RFS

Your reference: SSD-71547218
Our reference: DA20240613002390-Response to
Submissions-1

**State Significant Development – Response to Submissions – Waste or resource management facility
1, 8 & 10 Styles Street & 145, 147 Mitchell Avenue Kurri Kurri NSW 2327, 3//DP586741, 1//DP1128108,
4//DP586741, 6//DP1251190, 1//DP1309128**

The NSW Rural Fire Service (RFS) has reviewed the *Kurri Kurri Integrated Resource Recovery Centre Response to Submissions Report* (Central Waste Plant Pty Ltd), prepared by EMM Consulting Pty Ltd (Alexandra Bishop, March 2026), including Appendix F (Report titled: *Updated Bushfire Consultant Response to RFS Submission*, prepared by Cool Burn Pty Ltd. Ref J317, dated 16 March 2026).

**Proposed Site Plan**  
 Scale: 1 : 500

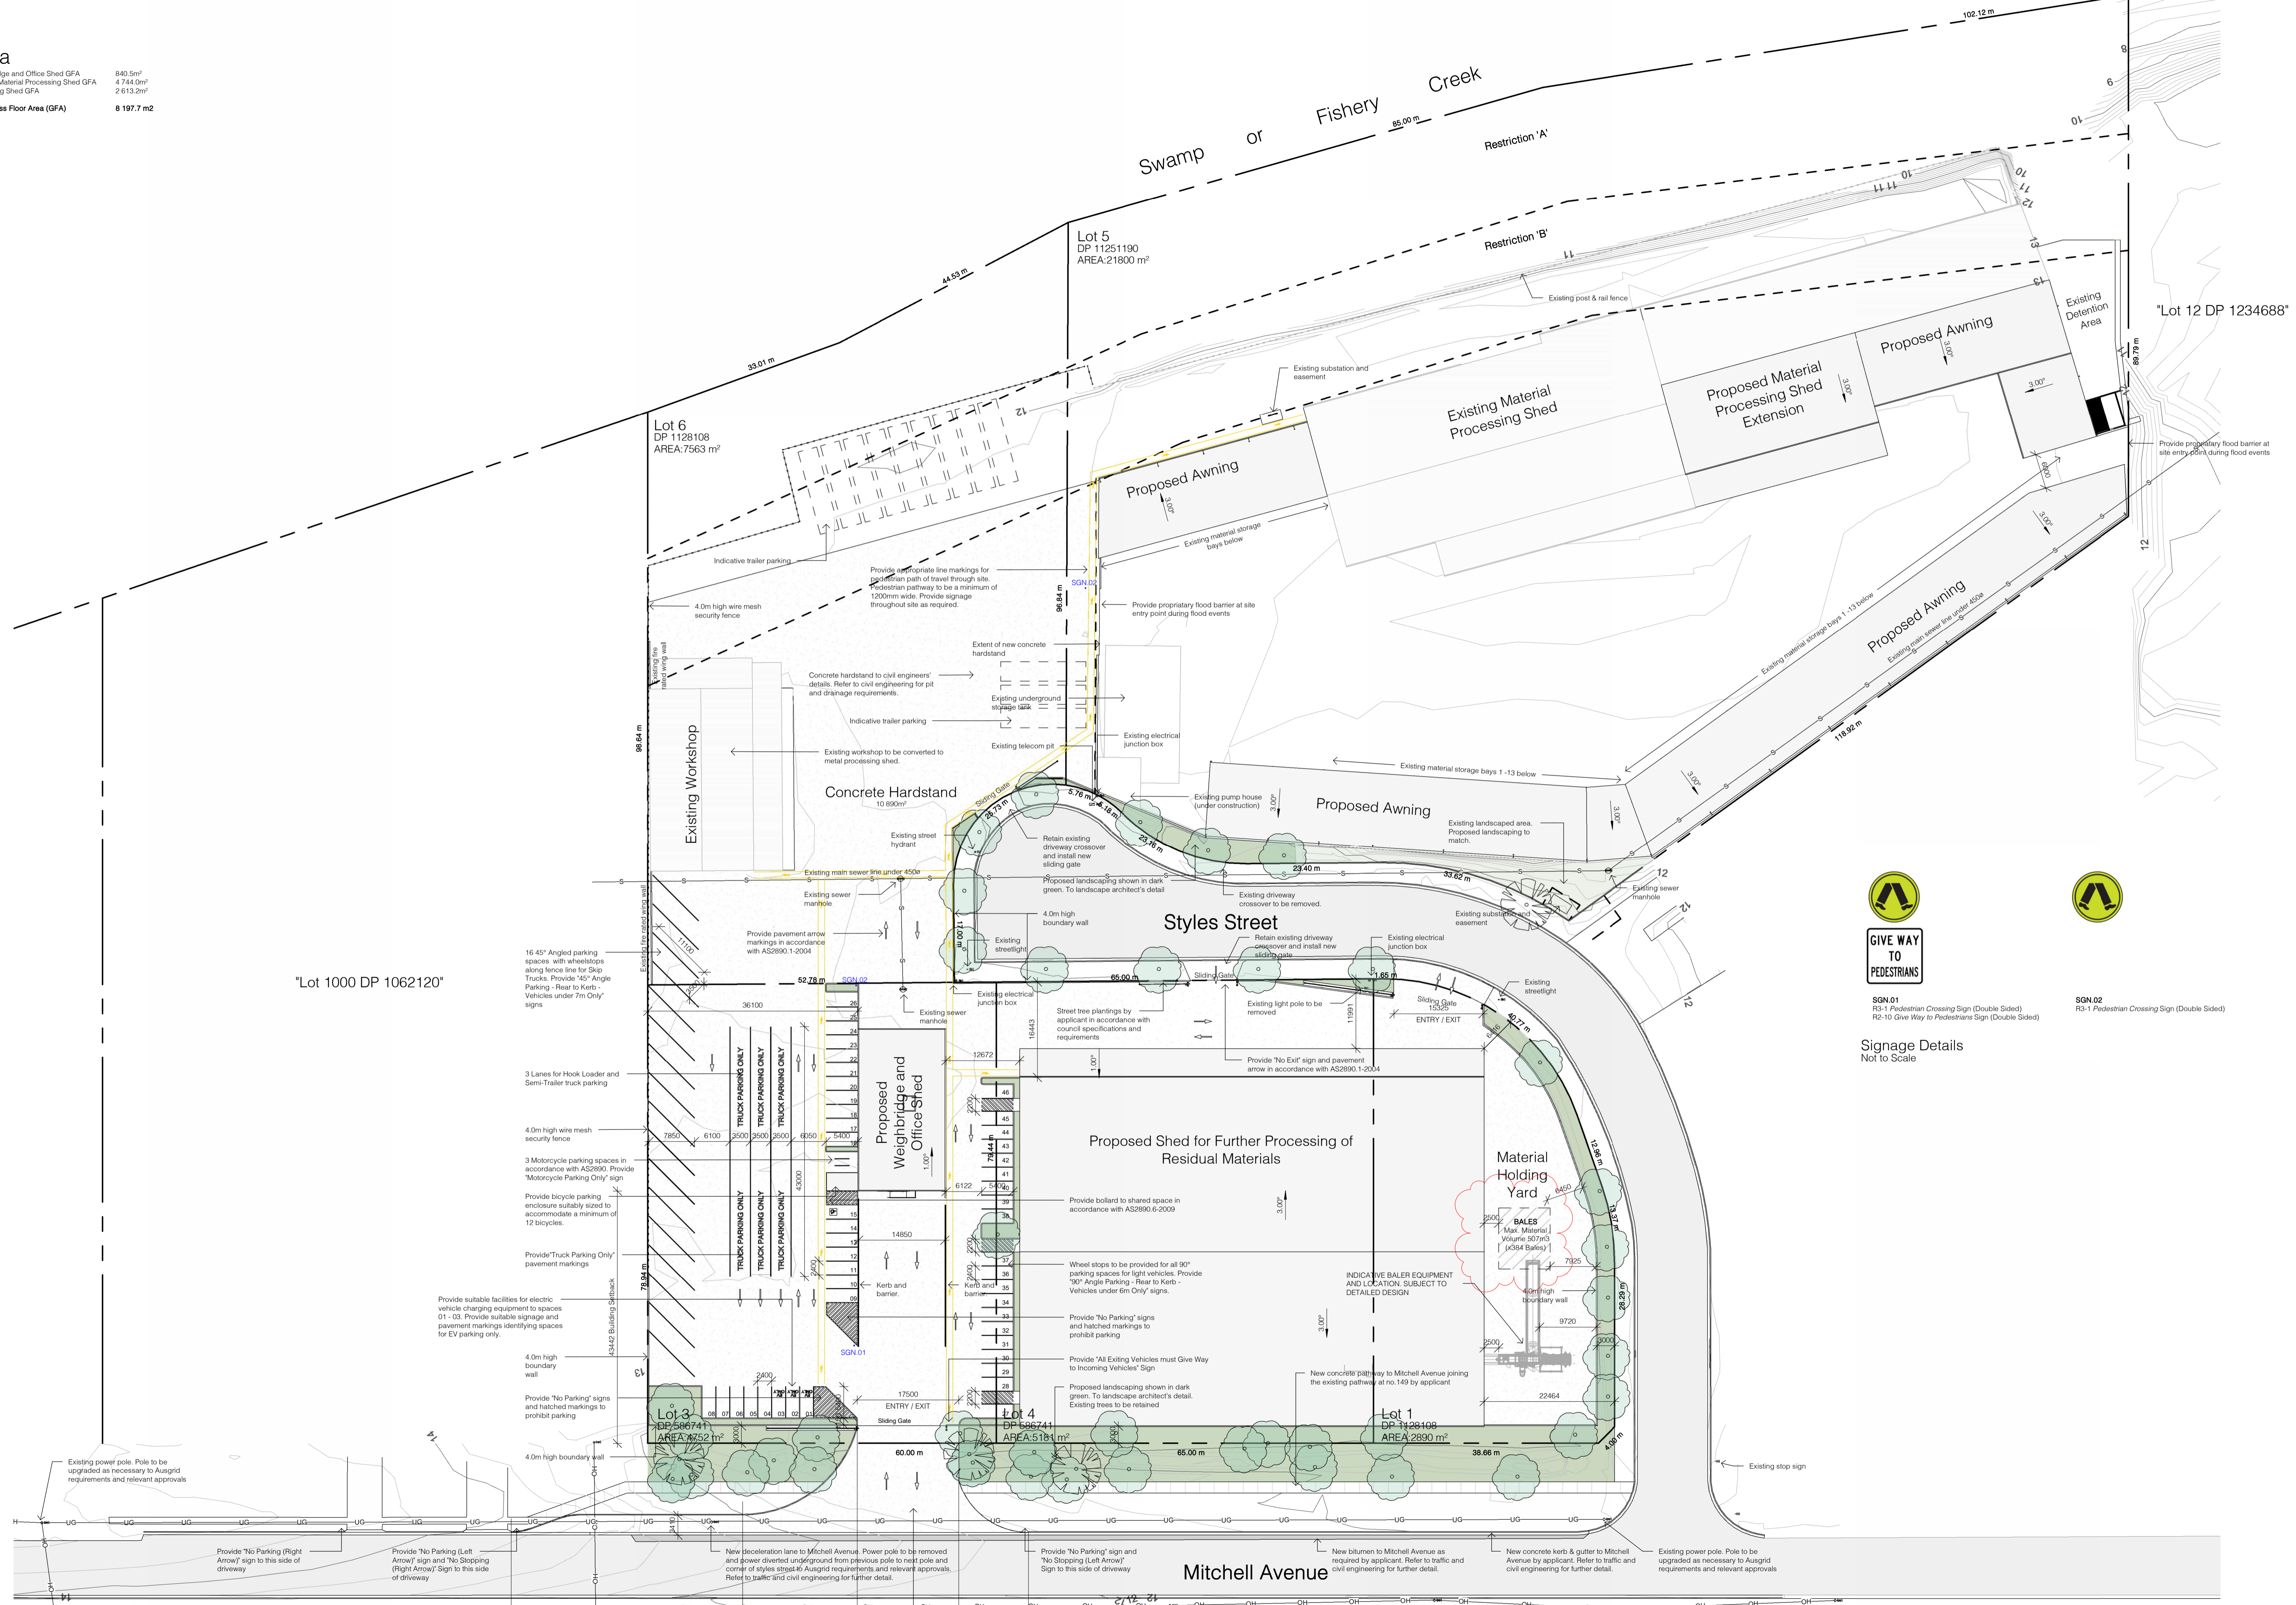
1. From the start of building works, and in perpetuity to ensure ongoing protection from the impact of bush fires, the entire property, must be managed as an inner protection area (IPA) in accordance with the requirements of Appendix 4 of *Planning for Bush Fire Protection 2019* as follows:

- North for a distance of 12 metres (incorporating the existing gravel access driveway and managed verge); and,
- Up to site boundary in all other directions.

2. Prior to the commencement of building works and in perpetuity, a suitably worded instrument(s) pursuant to Section 88B of the *Conveyancing Act 1919* must be within the subject site as shown on proposed Site Plan prepared by Thomas and Associates Consulting Pty Ltd, (dated 09/10/2025, Project Ref: 230499, Dwg No: A103, Issue: G). The instrument must prohibit any habitable building construction within the proposed Asset Protection Zone (APZ). The APZ must be managed as an IPA in accordance with the requirements of Appendix 4 of *Planning for Bush Fire Protection 2019*. The name of authority empowered to release, vary or modify the instrument must be Cessnock City Council.

Weighbridge Shed - Ground Floor Plan  
Scale: 1 : 100

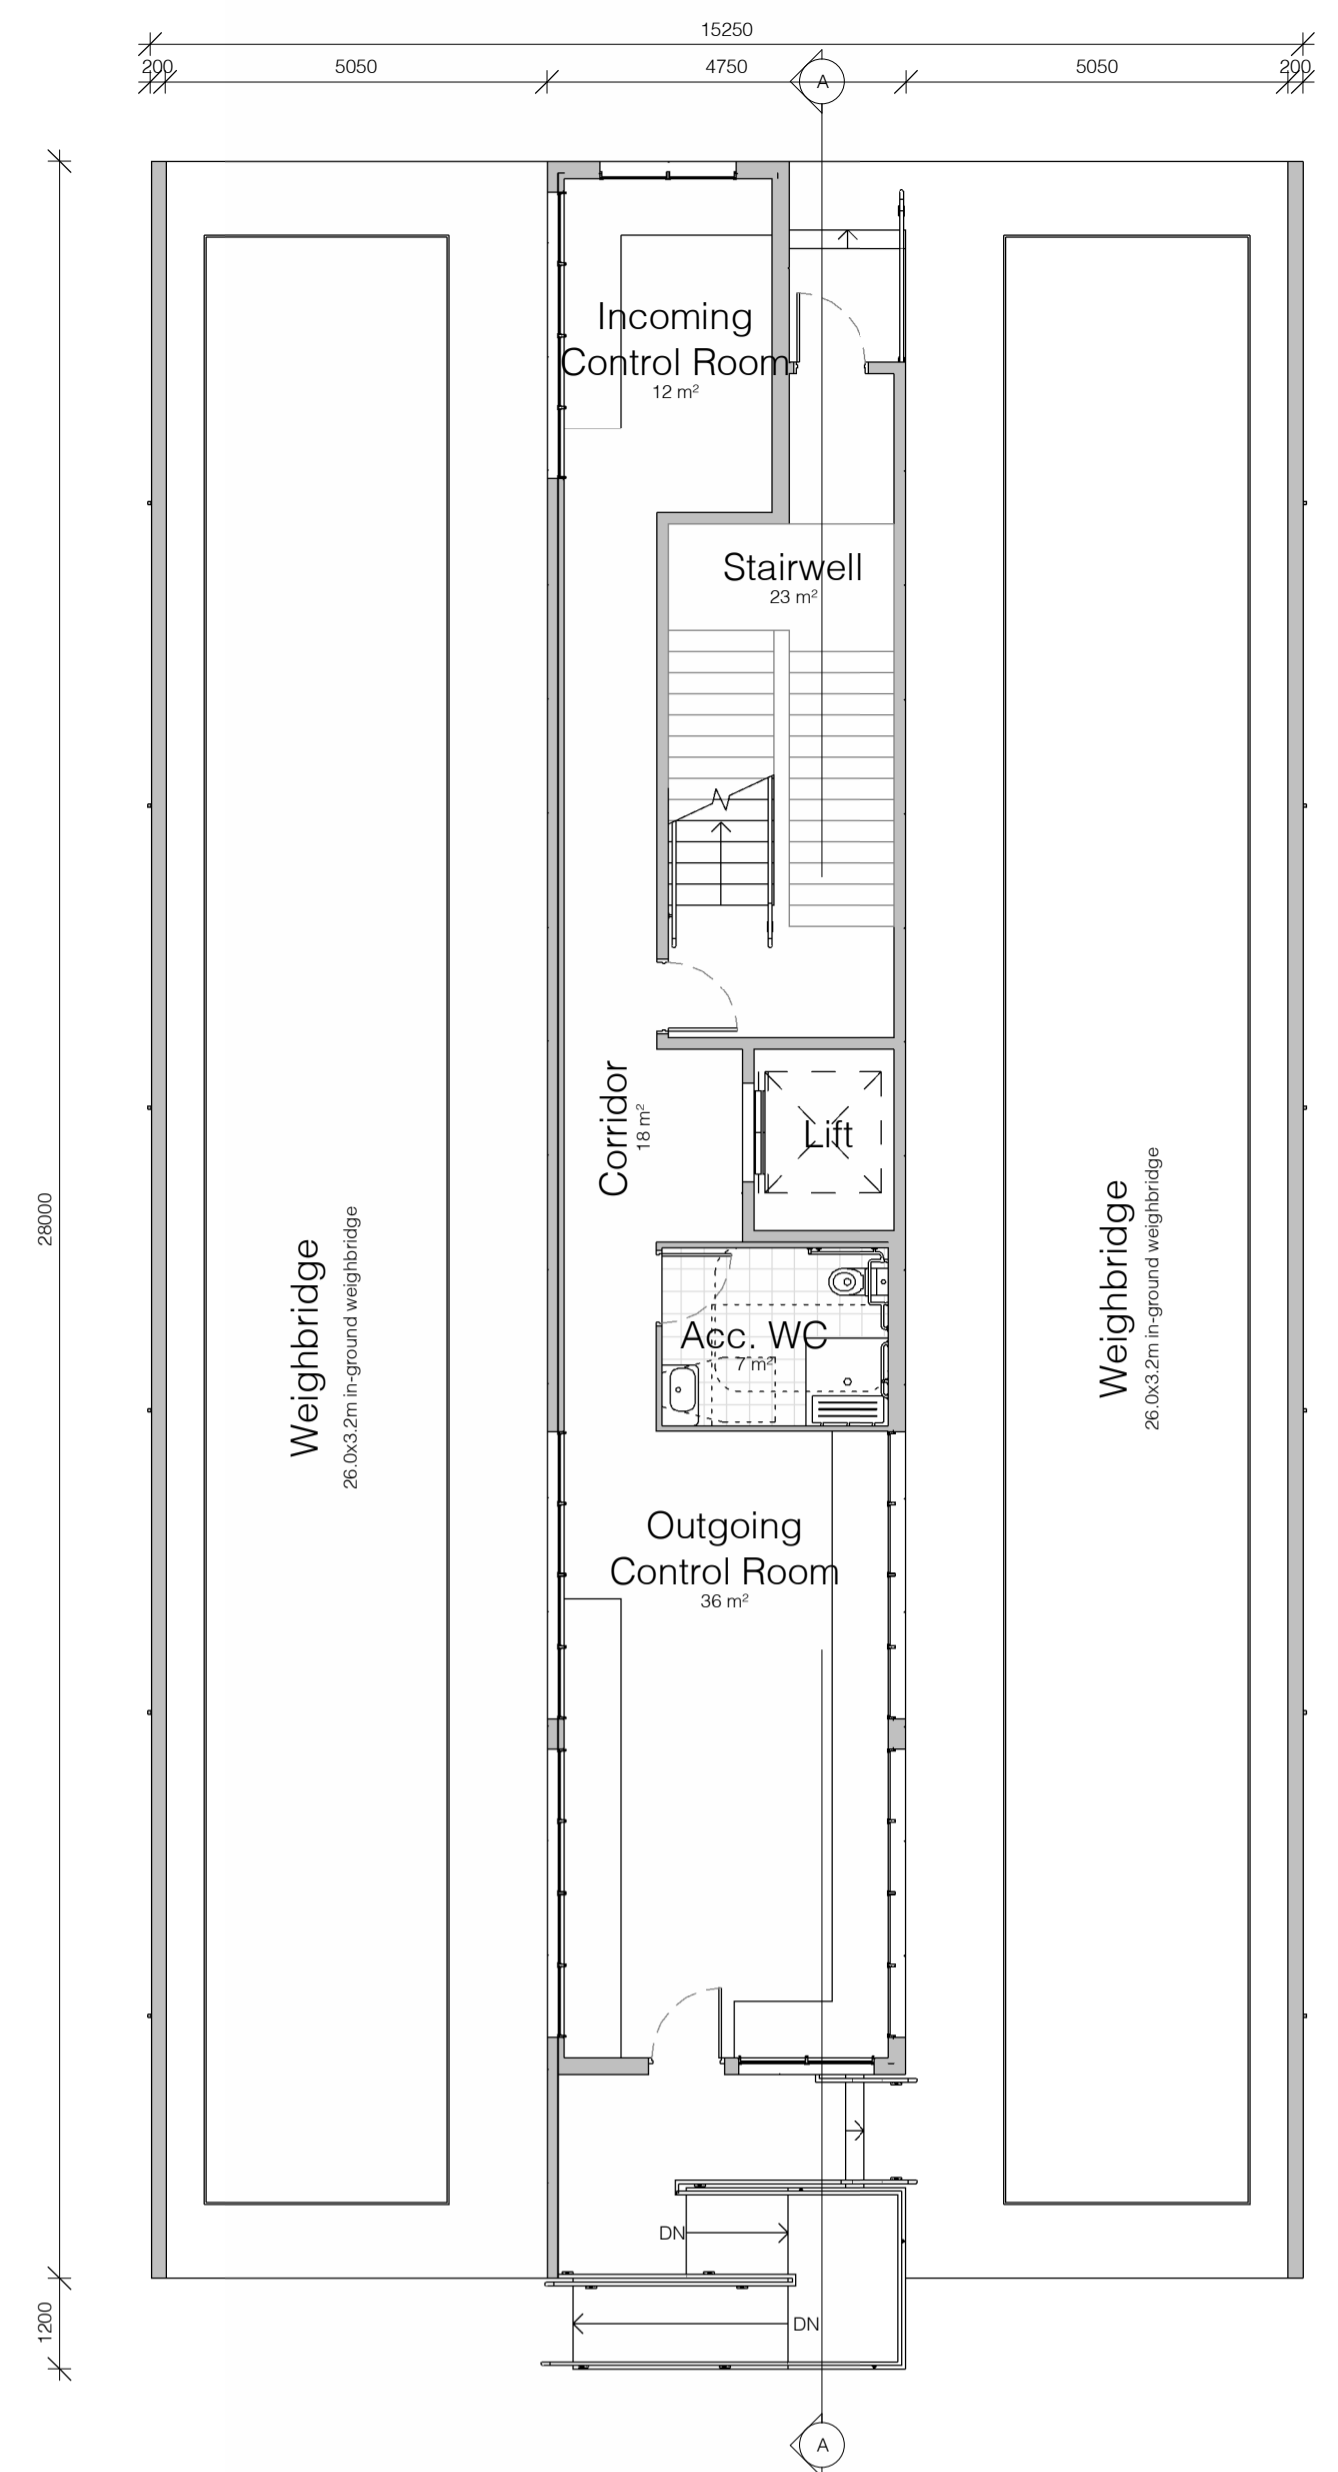
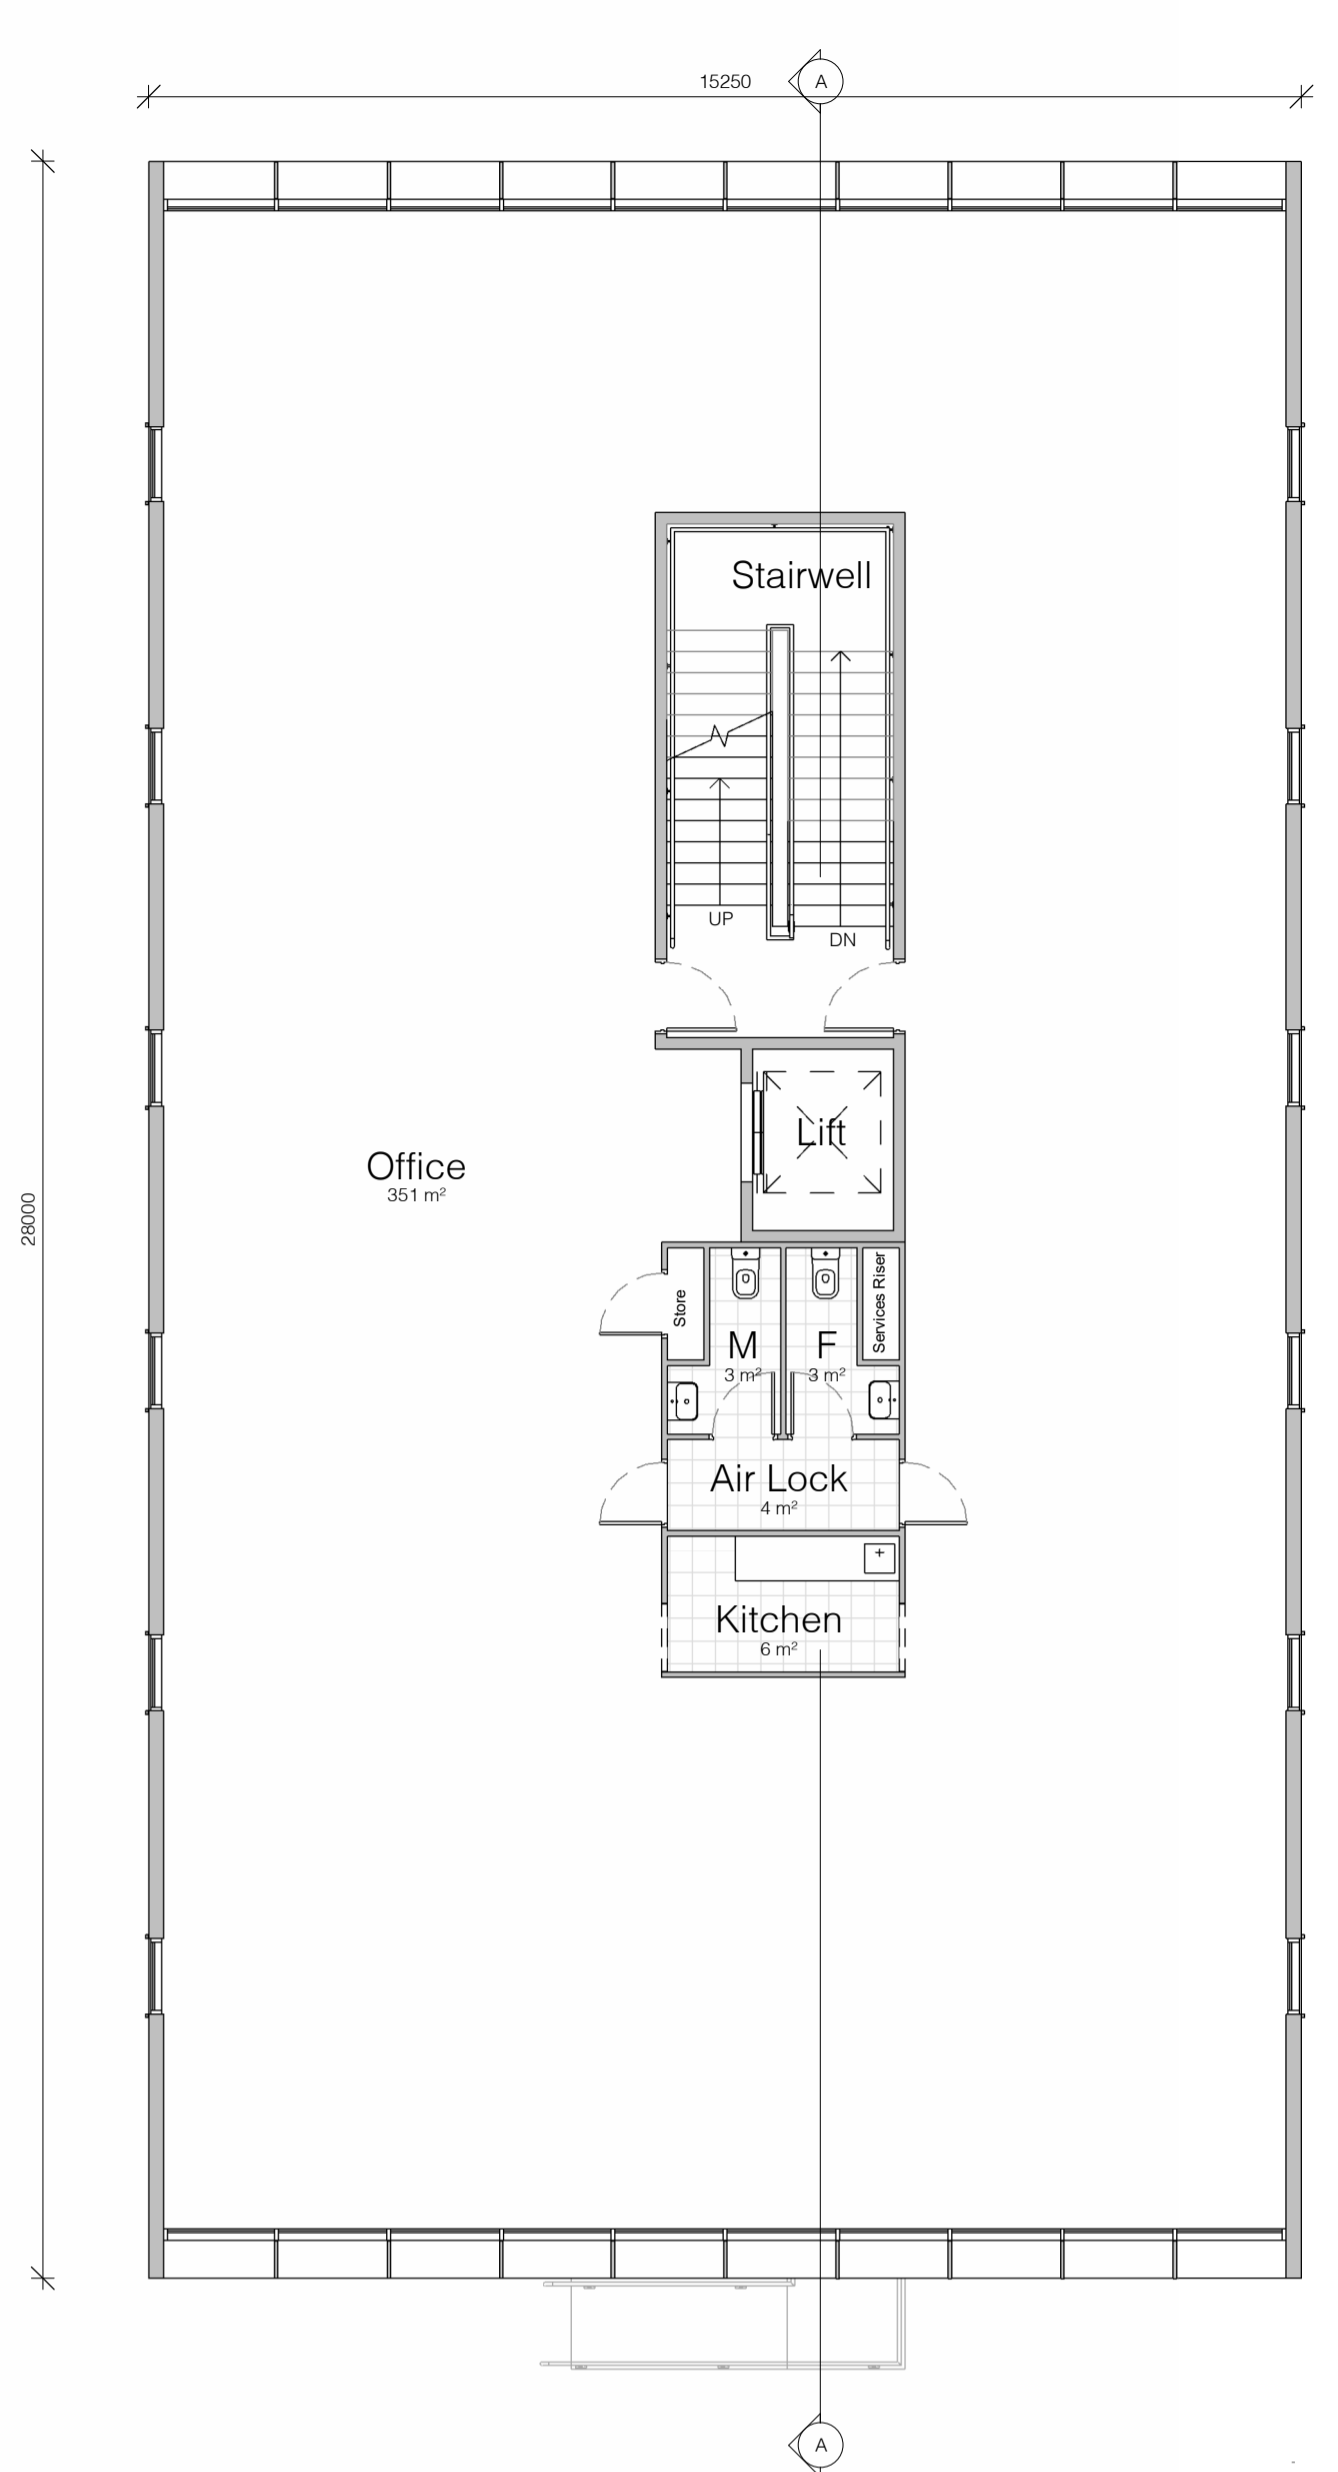
4. The proposed offices located above the weighbridge, must be upgraded to improve ember protection by enclosing all openings (excluding roof tile spaces) or covering openings with a non-corrosive metal screen mesh with a maximum aperture of 2mm. Where applicable, this includes any sub floor areas, openable windows, vents, weepholes and eaves. External doors are to be fitted with draft excluders.
